**Consultation Response from KC Landscape**

<b>Application No:</b>	2025/93355
<b>Proposed Development:</b>	Erection of 75 residential dwellings with associated landscaping, open space, highways and drainage infrastructure
<b>Location:</b>	Land off, Woodward Court, Mirfield, WF14 0PY
<b>Applicant/Agent:</b>	Paul Butler PB Planning Ltd
<b>Planning Officer</b>	Katie Chew
<b>Date Responded:</b>	02.02.2026
<b>Responding Officer:</b>	Landscape
<b>Responding Ref:</b>	PP38

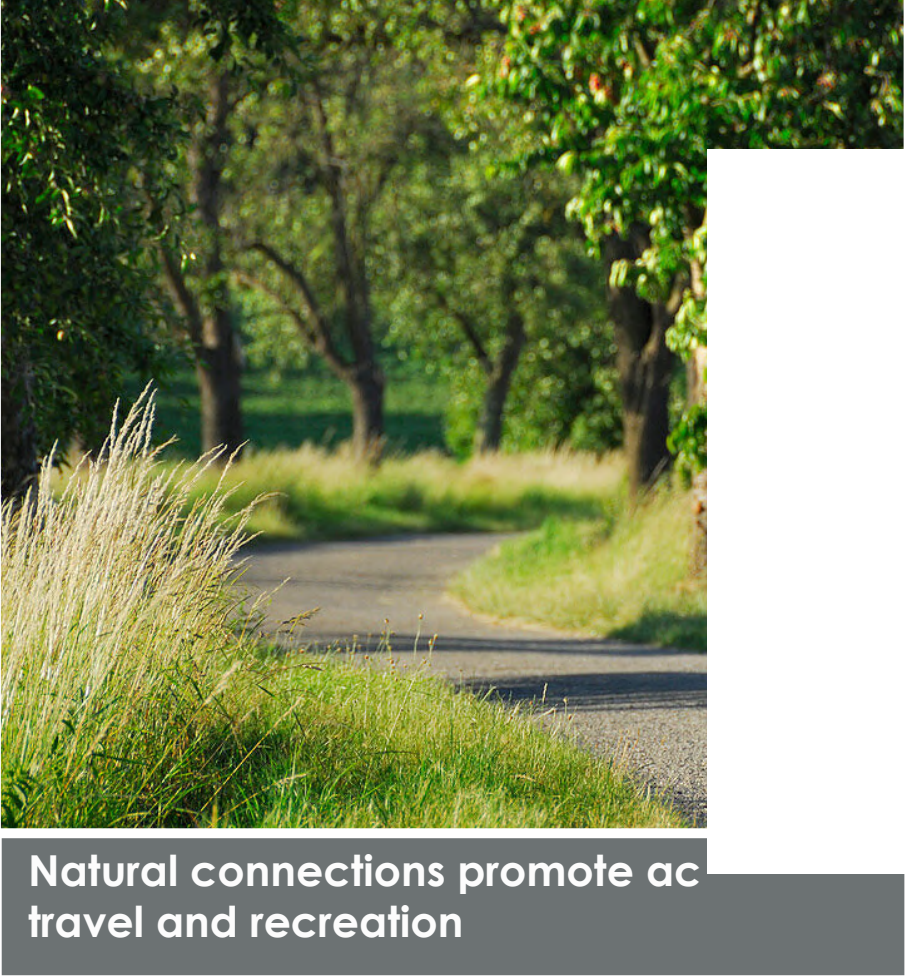
Setting – this layout for 75 dwellings on safeguarded land.
- The plan is very indicative in landscape terms, therefore difficult to provide meaningful comments, however, some greenspace on site is shown and is welcome, however, consider access and purpose of the spaces being created. Will the spaces provided meet the needs of the widest possible range of users, be easily accessible and enjoyed by all people, regardless of visual, physical and cognitive ability, mobility, background or age. Are some of the areas shaded green more likely highways verges or buffer and screen planting?

5. Plans should clearly show the impact of the proposed landscape planting on drainage infrastructure and visibility spays, particularly with proposed street trees and frontline tree planting/ trees in front gardens.

7. Access to local facilities – the new open space created to the southern part of the site does not appear to link to the PROW – this could also be one of the likely routes to the local play area and recreation ground to the east.

14. The plans submitted /landscaping/ scheme documents do not appear to have considered enough street tree planting in the verges of the estate roads.
15. New developments are to retain and incorporate existing significant trees within the layout as stated within Kirklees Local Plan policy LP33. Tree planting adjacent to carriageways accords with the West Yorkshire Combined Authority's "Green Streets" principles, as well as paragraph 136 of the NPPF.

23. Preference is for native plants and for plants proven as beneficial to pollinators where possible for this location. Native, fruit bearing species preferred where appropriate. There are some indicative species lists on the proposed landscape layout plan.

24. Crataegus sp are welcomed as native, however, being a high water demand tree can potentially cause issues with foundations so it's generally not usually planted within 10m minimum distance so that the house foundations don't need to be deepened –clearly show on plans the mitigation if it is within 10m. Plans should also clearly show the impact of the proposed landscape planting on drainage infrastructure

Indicative LEAP Proposals

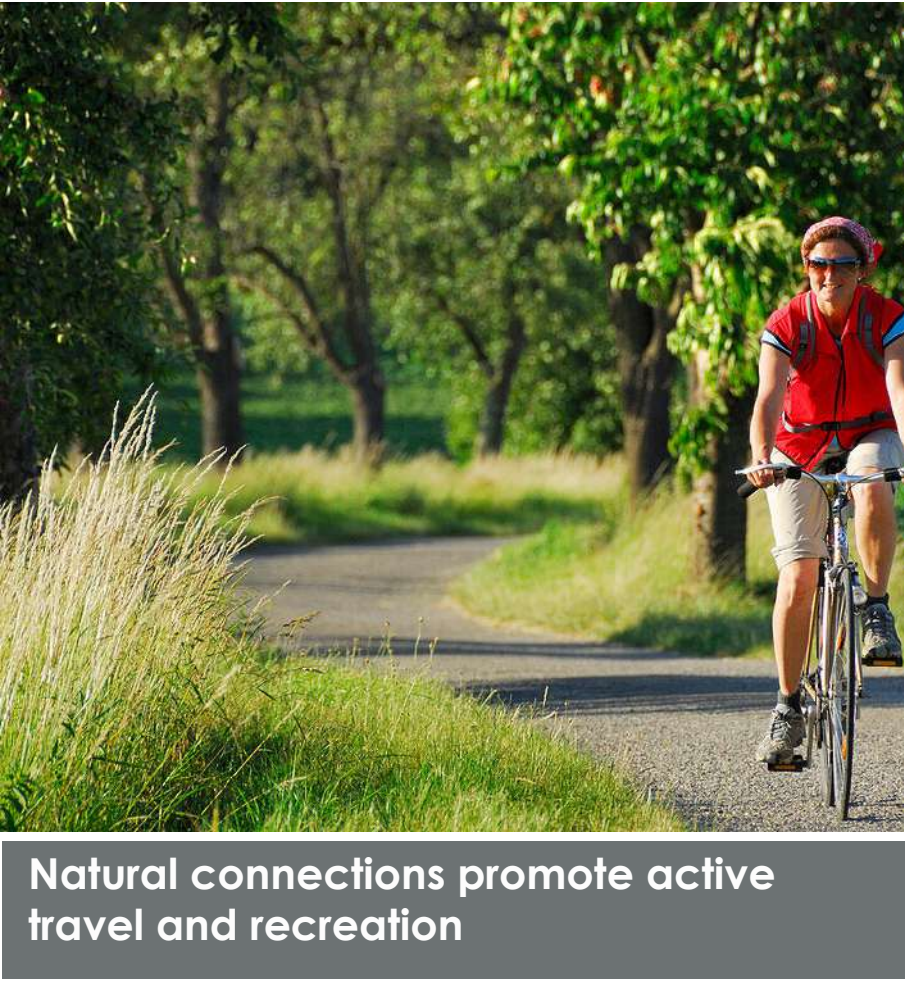
35. Any separation distance from LAP's, LEAPs, NEAPs and MUGA's should be measured to the boundary of the garden not the residential property itself. The Environmental Protection Act considers gardens as premises, and the boundary is where anything should be measured to/from. The play equipped areas will therefore need a 20m buffer from the garden boundaries if on site provision is included.

36. Dwelling triggers for Children & Young Peoples Provision: 75dwellings does trigger CYPP – a LEAP
